# Gatwick Airport Northern Runway Project

## Notification of Proposed Project Changes

DATE: November 2023

Application Document Ref: 9.1

Additional Footpath Route during construction of Water Treatment Works

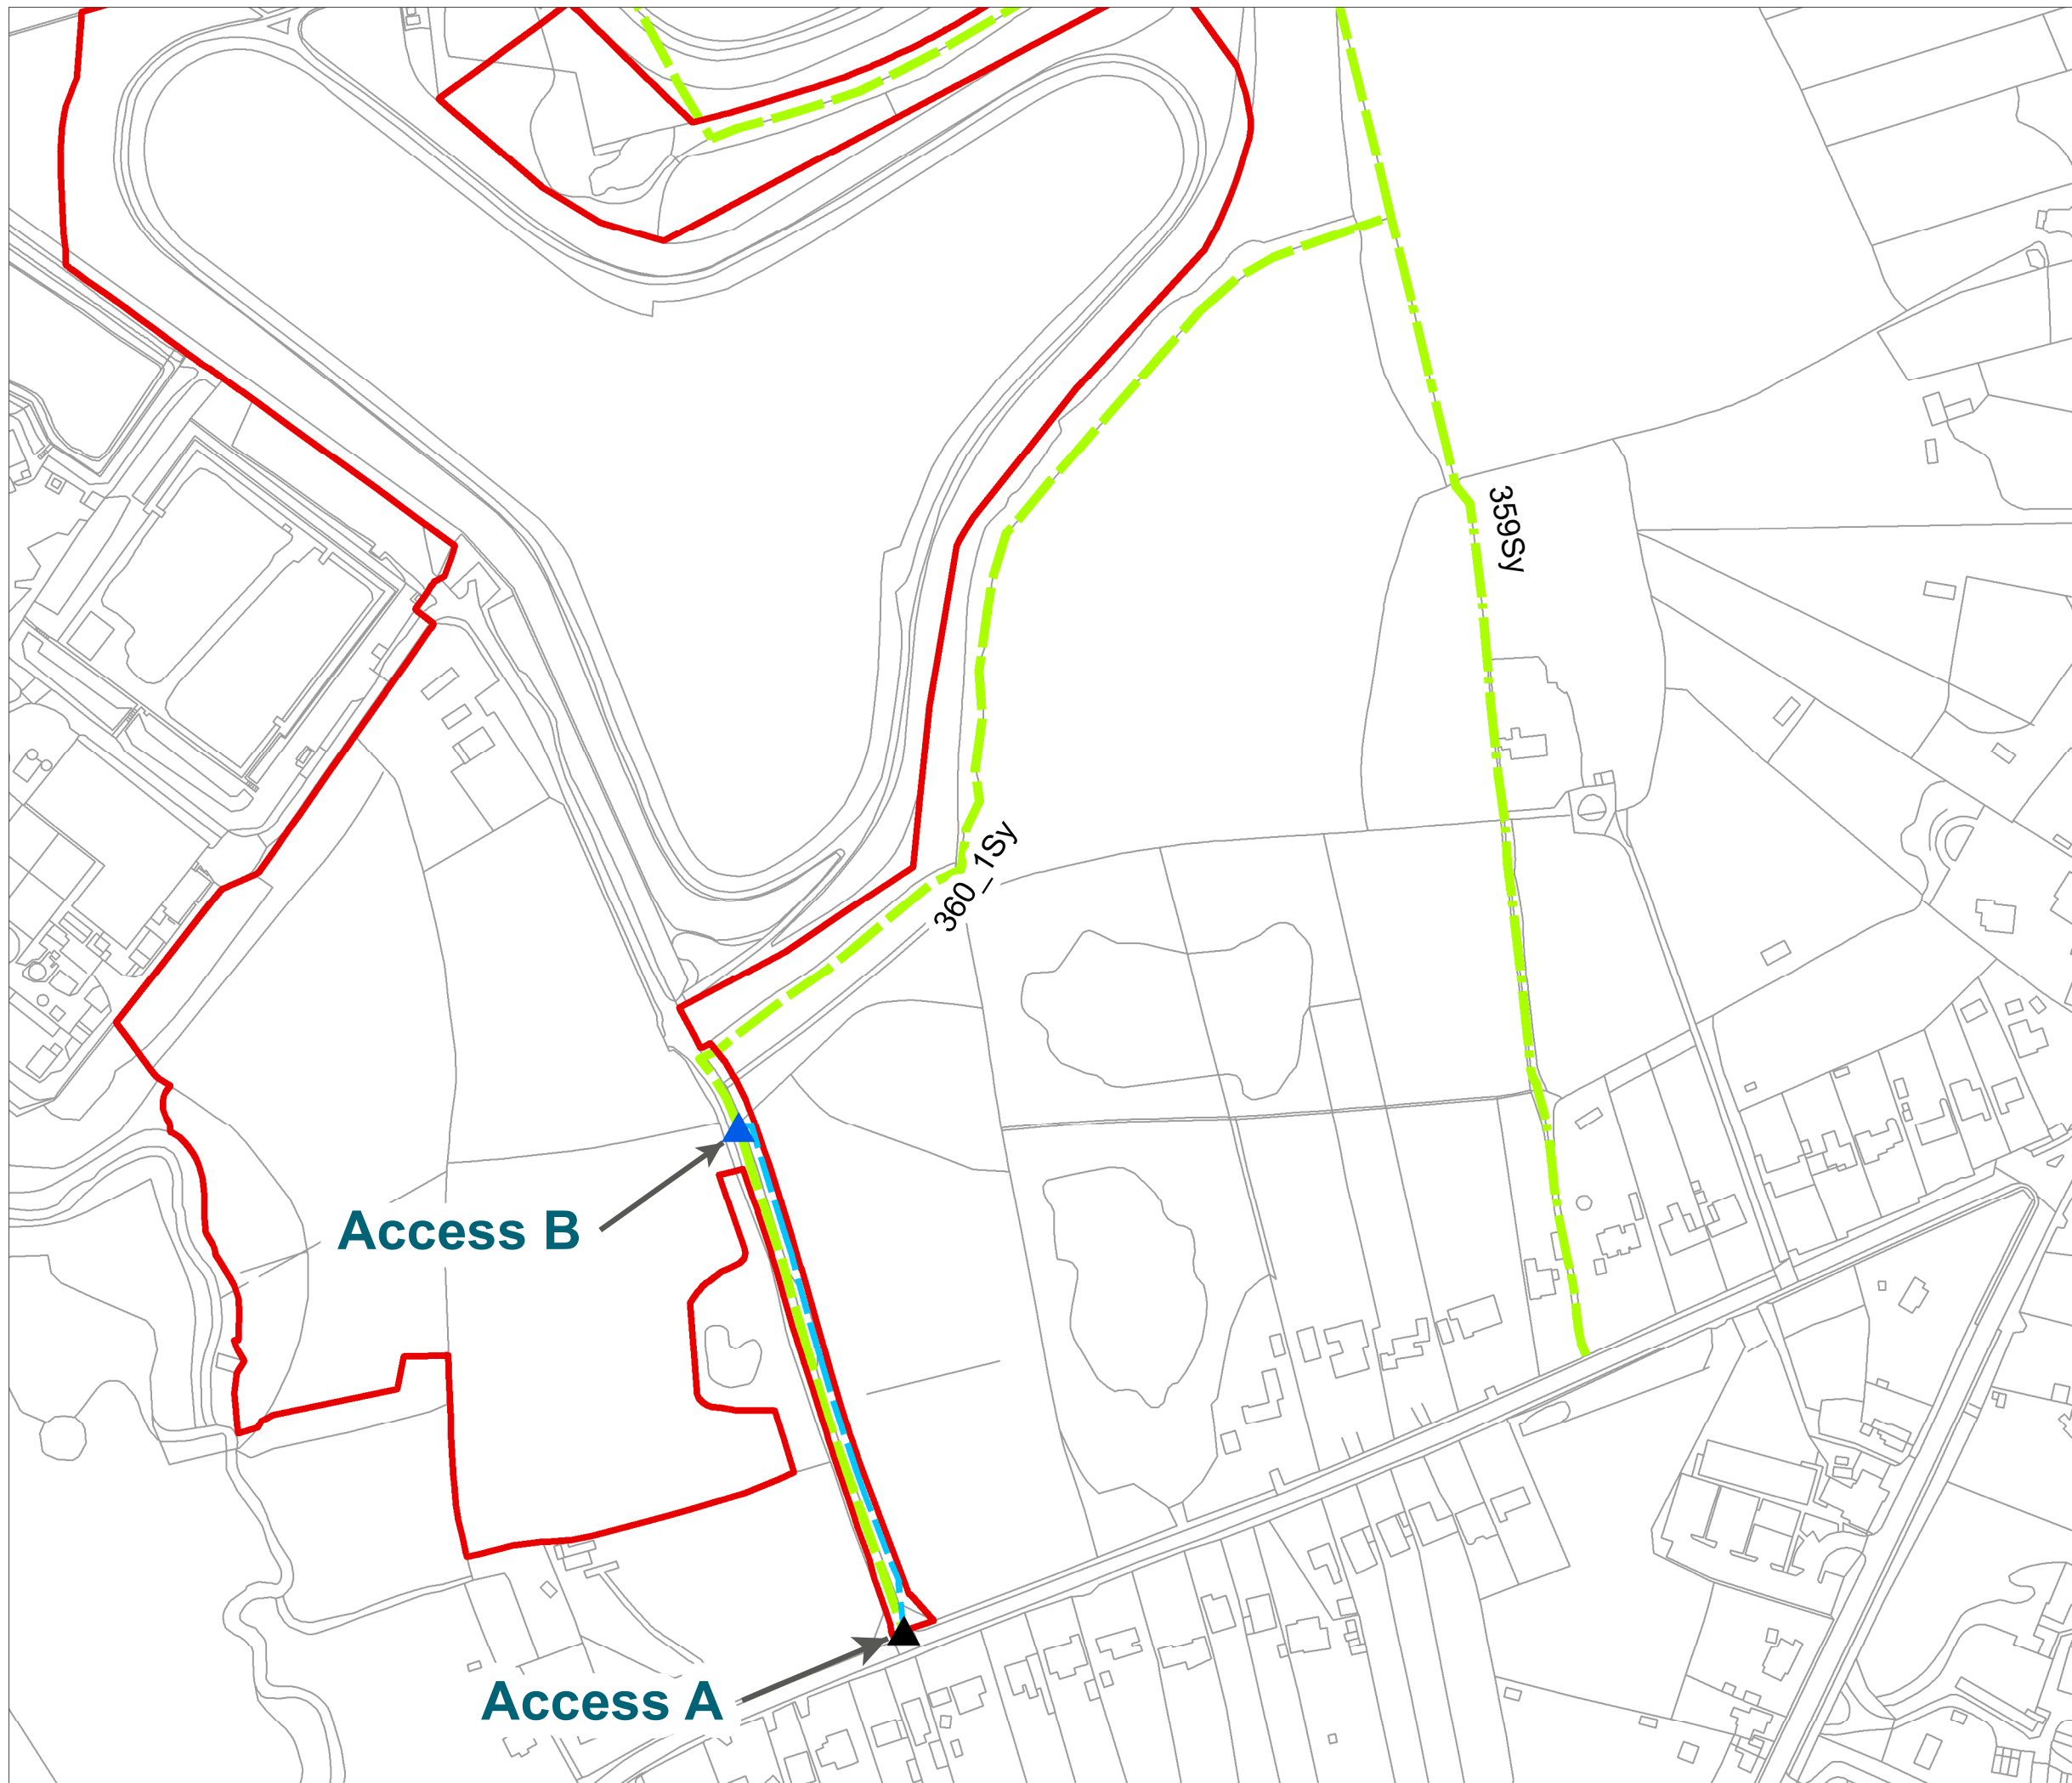
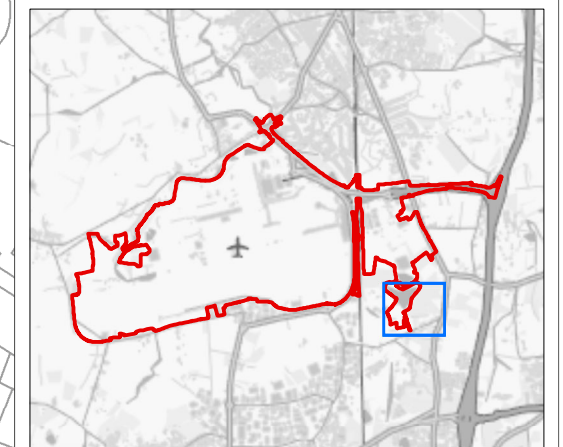
- Change to the water treatment process from a Moving Bed Biofilm Reactor (MBBR) process to a constructed wetland (reed bed) system entailing different structures and features (described further below).
- Increase in the footprint for the proposed water treatment works to accommodate the reed bed system from up to 5,600m<sup>2</sup> to an area of approximately 16,000m<sup>2</sup> (16 hectares). The additional land to accommodate the reed beds is located to the south of the area previously proposed for the MBBR system, within the existing Order Limits.
- Provision of an additional temporary construction compound up to 5,000m<sup>2</sup> (0.5 hectares) in area.
- Provision of a temporary 2.4m high noise barrier during construction, located along the south side of the southern pond.
